EPC STORMWATER REVIEW COMMENTS ARE SHOWN IN ORANGE BOXES WITH BLACK TEXT

2022 Financial Assurance Estimate Form
(with pre-plat construction)

PROJECT INFORMATION		
Saddlehorn Ranch Filing 2 Improvements Early Grading	5/12/2022	EGP221
Project Name	Date	PCD File No.

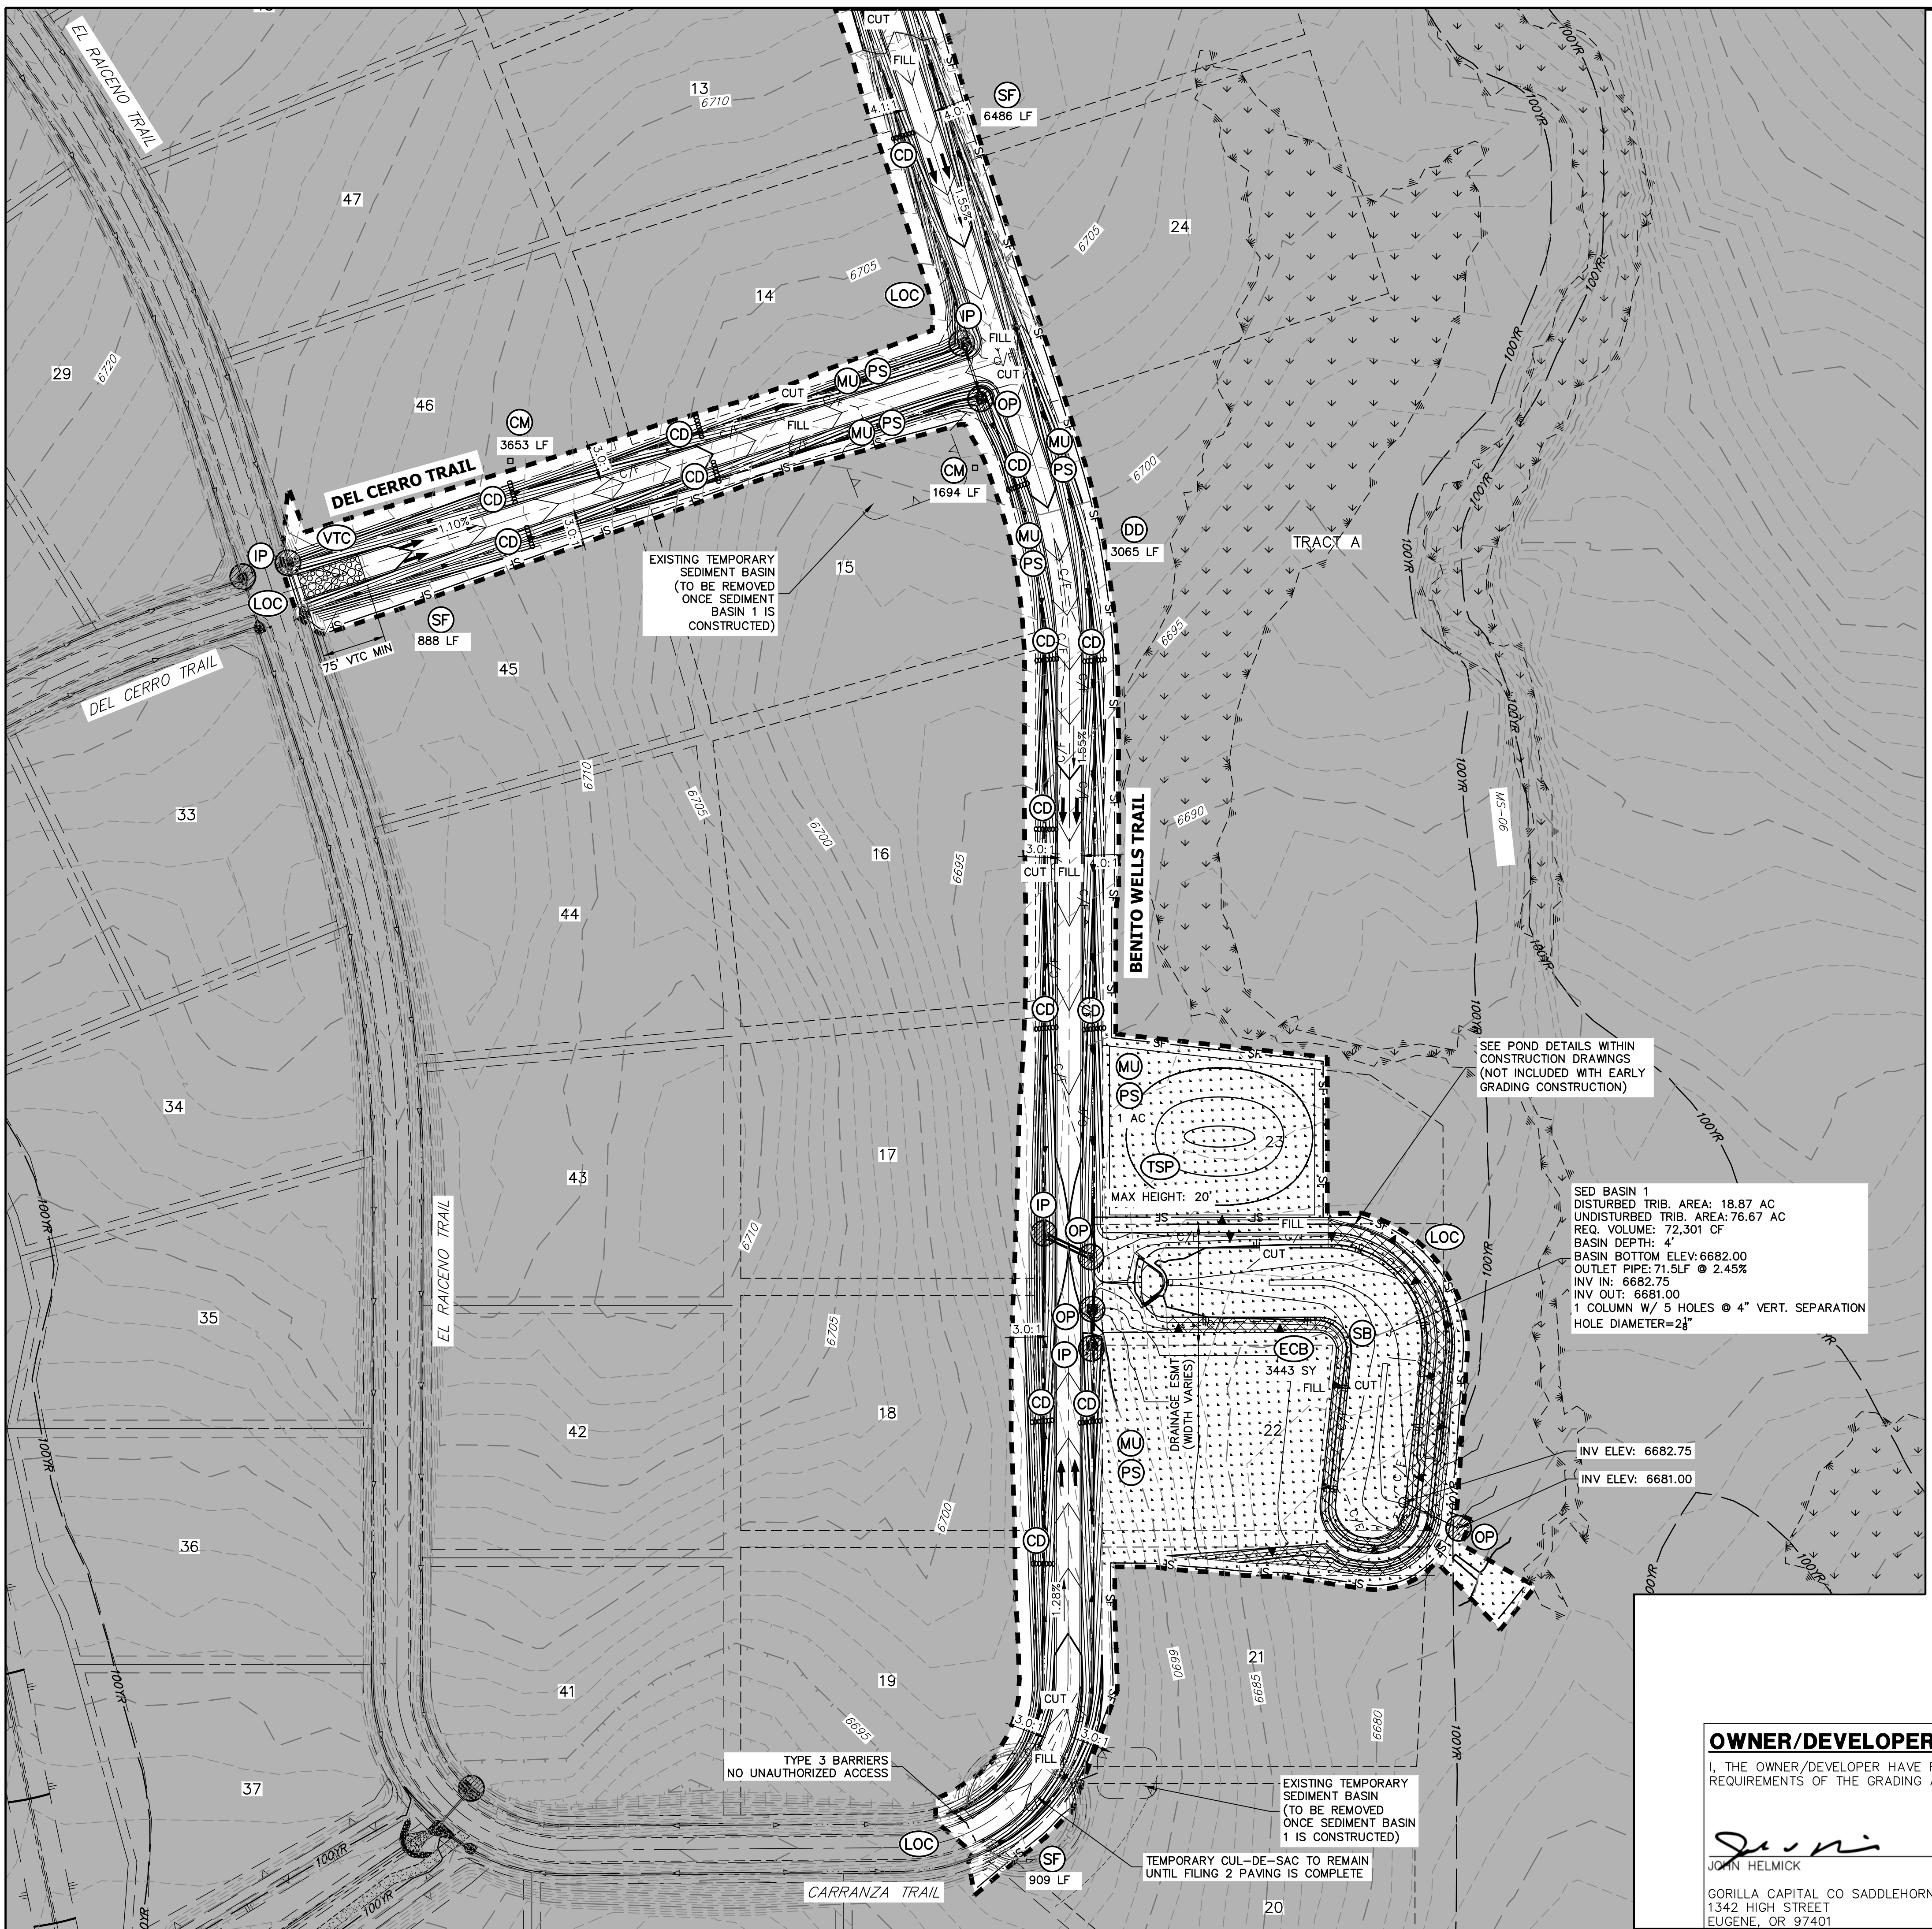
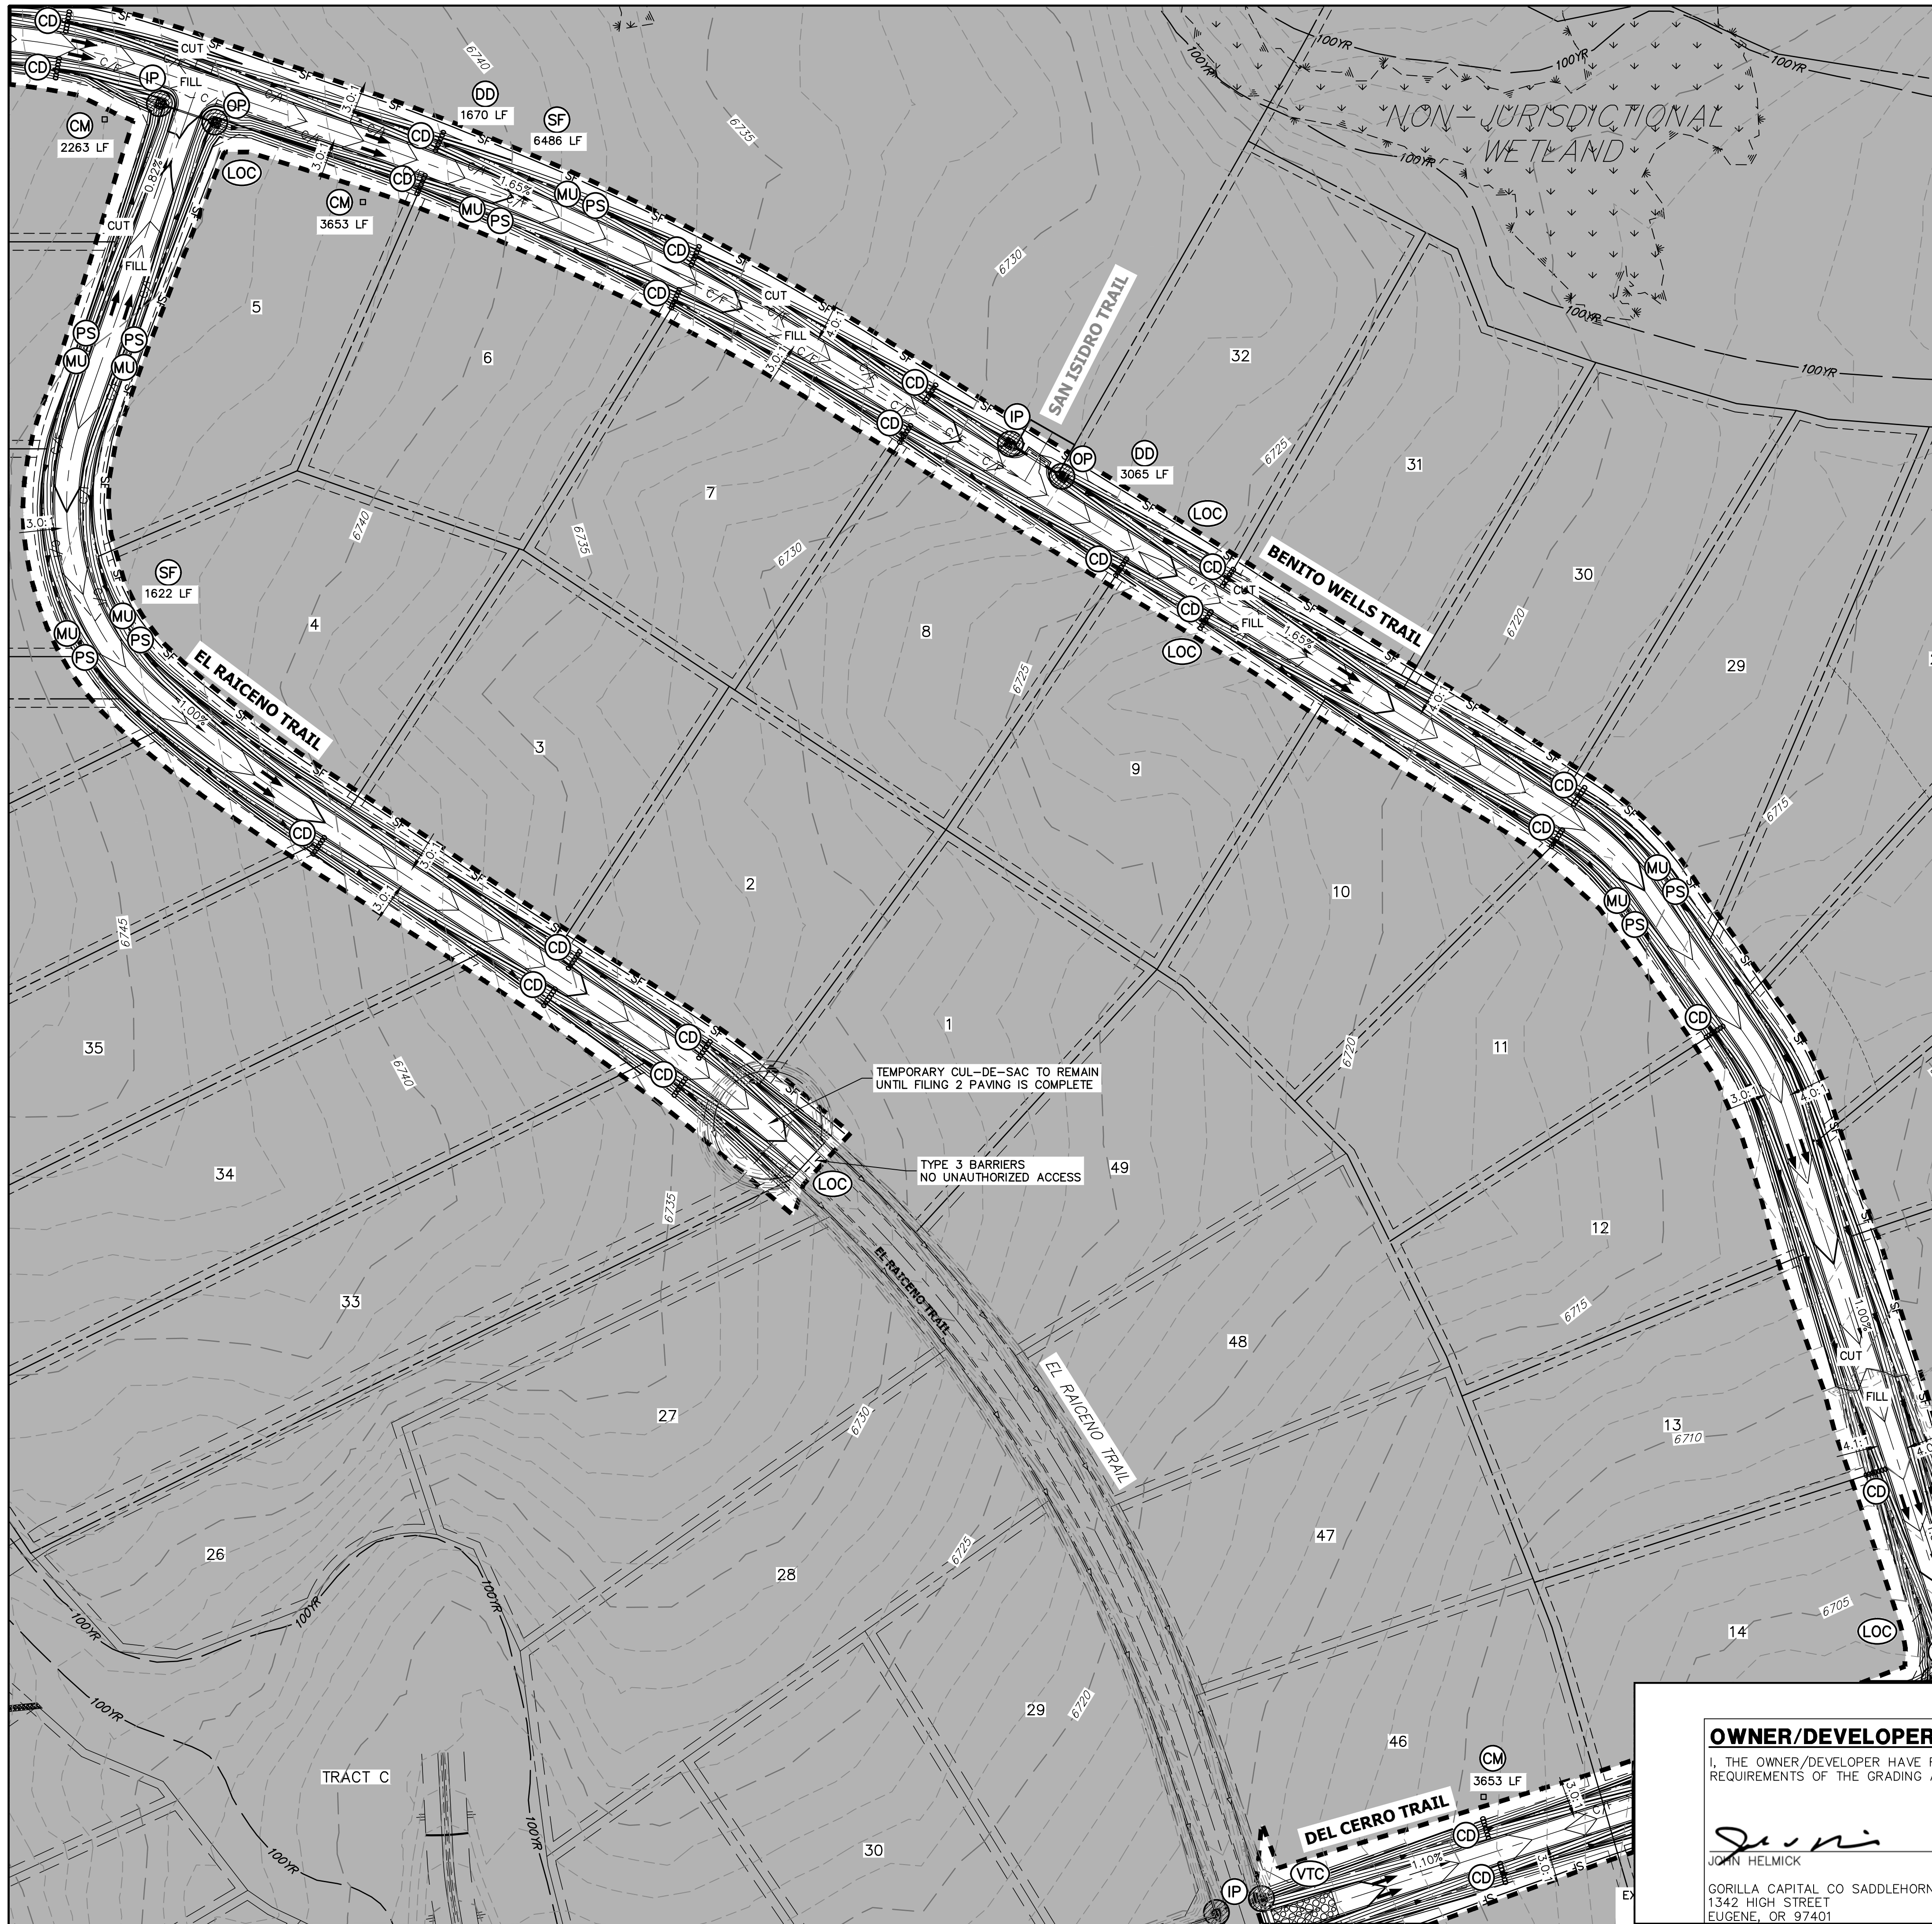
Add emergency spillway since this got added in the latest GEC submittal

update for 15' wide access road

Add the following items since these are shown on the GEC and/or noted as being constructed in the FDR narrative:
 - Pond F forebay
 - Emergency Spillway
 - Pond outfall spreader/riprap
 - Riprap rundown into the forebay
 - Trickle Channel
 - Concrete Washout Basin
